HINCKLEY NATIONAL RAIL FREIGHT INTERCHANGE

Appendix 14 - Gibbet Hill Mitigation Road Safety Audit Stage 1

Stage 1 Road Safety Audit
RESPONSE REPORT GIBBET HILL

Report Title:	Hinckley National Rail Freight Interchange – Stage 1 RSA Gibbet Hill
Document Number:	HRF-BWB-HGN-RSA-RP-CH-0007
Prepared By:	BWB Consulting Ltd
Overseeing Organisation:	National Highways
BWB Reference:	NTT2814

GIBBET LANE NB  
(HGV)

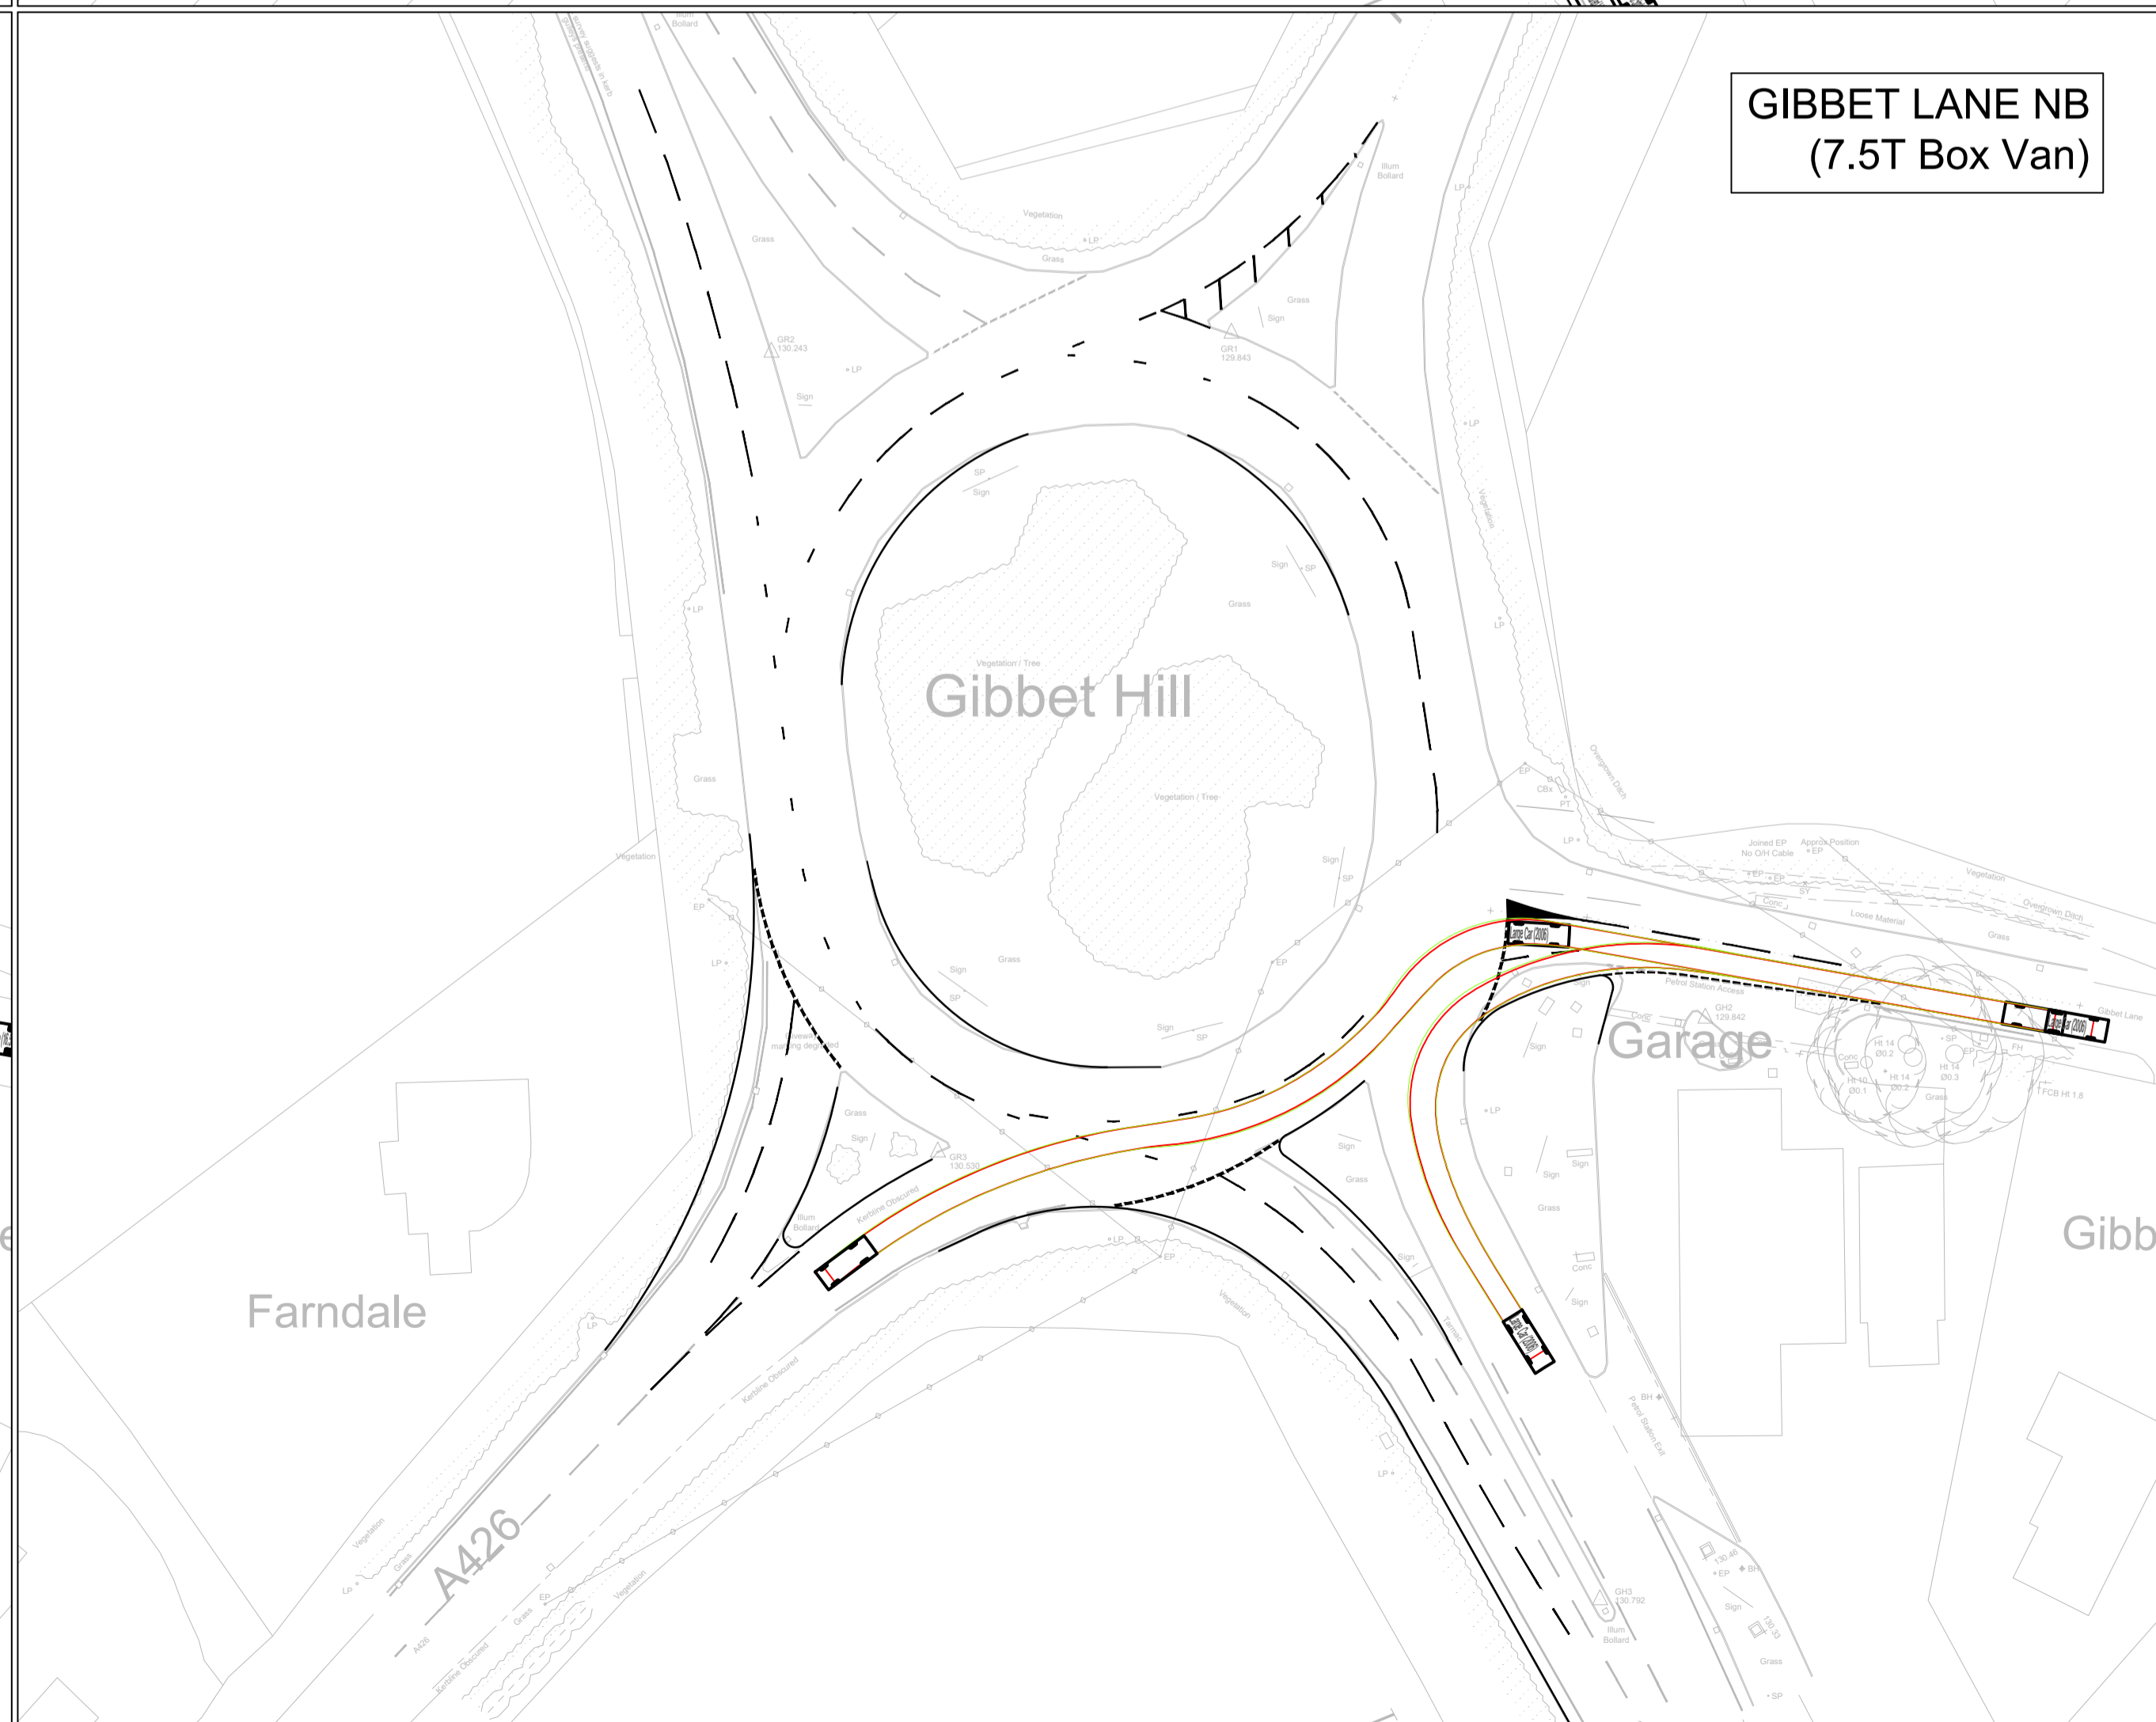
RSA Ref.	RSA Problem and Recommendation	Design organisation response	Auditor Response	Agreed RSA action
2.3	<p>Location: General to the scheme</p> <p>Summary: Potential collisions associated with insufficient circulatory width</p> <p>The formalisation of the two lane entries from A5 northbound, A426 eastbound and Gibbet Lane is likely to increase the occurrence of vehicles, particularly HGVs, using the circulatory carriageway two abreast. While the swept path drawings supplied to the RSA team suggest that this is achievable, site observations showed that there is evidence of significant overrun of the central island kerb line (on both the west and east sides) suggesting that there is insufficient width on the circulatory to safely accommodate two HGVs. This is compounded by the lack of road markings on the roundabout circulatory and all exits from the roundabout are single lane. Collectively this could lead to an increase in collisions on the circulatory, and side swipe collisions at the exits as two vehicles attempt to leave the roundabout at the same time.</p> <p>There is also a risk of an increase in HGVs overrunning the verge and central island bringing mud onto the carriageway which is particularly hazardous for powered two wheelers.</p> <p>Recommendation</p> <p>Review the swept path at the junction taking into consideration what could be happening in reality at present at the roundabout and if necessary, revise the kerb lines around the circulatory to ensure sufficient width is provided as part of the scheme.</p>	<p>Agree with RSA Recommendation: Yes</p> <p>Swept paths have been rerun and the roundabout circulatory carriageway has been widened in a number of places where vehicle overrunning is a risk in order to provide sufficient space between swept paths. New road markings on the circulatory carriageway are proposed to guide vehicles to the correct destination and mitigate the risk of vehicle overrunning or conflict.</p>

RSA Ref.	RSA Problem and Recommendation	Design organisation response	Auditor Response	Agreed RSA action
2.4	<p>Location: General to the scheme Summary: Potential collisions resulting from a lack of road markings</p> <p>There is a general lack of road markings on the approaches to and exits from the roundabout. Increasing the number of entry lanes in turn increases the number of vehicles on the negotiating the roundabout at any one time. Many of the users will be unfamiliar with the area and the lack of road markings could lead to incorrect positioning resulting in late lane changes or hesitation which in turn could result in collisions.</p> <p>Recommendation Provide sufficient road markings on approach to, exits from and on the circulatory of the roundabout.</p>	<p>Agree with RSA Recommendation: Yes</p> <p>New road markings have been proposed throughout the junction to ensure that vehicles are in the correct lane and to mitigate the risk of conflict.</p>
